**WEST SUSSEX COUNTY COUNCIL
PLANNING SERVICES CONSULTATION**

SUBJECT: LU/17/162 - Demolition of existing building, erection of 10 residential dwellings (Use Class C3) with associated open space, landscaping, parking, and access. Departure from the Development Plan.

LOCATION: Land North & West of Toddington Farm Cottages, Toddington Lane, Wick, Littlehampton, West Sussex, BN17 7PP.

This is the third WSCC highways and transport response to the above application. It follows review of additional information provided by the applicant – namely 'Site Layout – Proposed' drawing number (00) 002 Revision 'F' and 'Transport Response to West Sussex County Council' reference number 30917/D03 dated October 2017. This report should be read alongside previous WSCC highways reports dated 24th July and 19th September 2017.

30917/AC/001

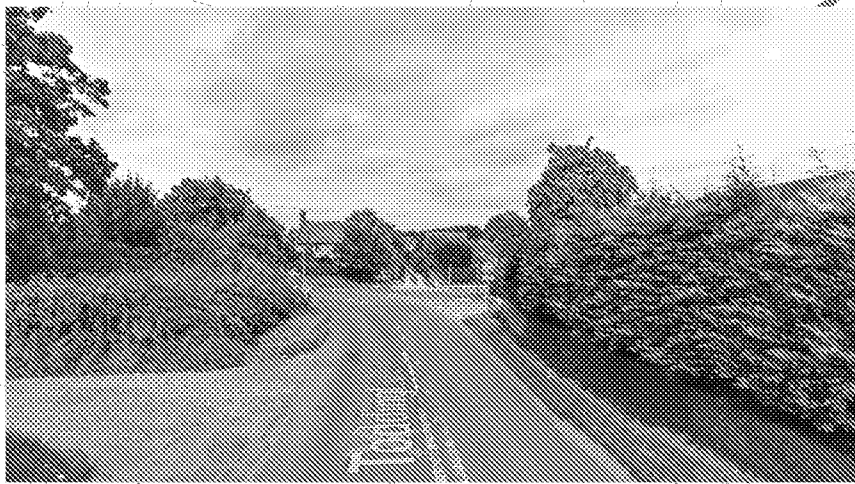
1. 2.2 – While a swept-path diagram is provided showing the manoeuvre of a service vehicle within the site, the problem raised in the RSA recommends that such vehicles will be able to manoeuvre to and from the *development access* safely. As such, a further swept-path diagram should be provided for the vehicular access where it meets Toddington Lane. While further swept path diagrams (SPD) have been provided, it is clear that to provide adequate access and egress for service vehicles, the access should be widened to at least 4.8m wide to ensure that vehicles can pass one-another in the access (the current SPD shows a large vehicle taking-up most of the width of the access). Also, the SPD and any revised plan should be presented to the Road Safety Audit Team for further review and comment.
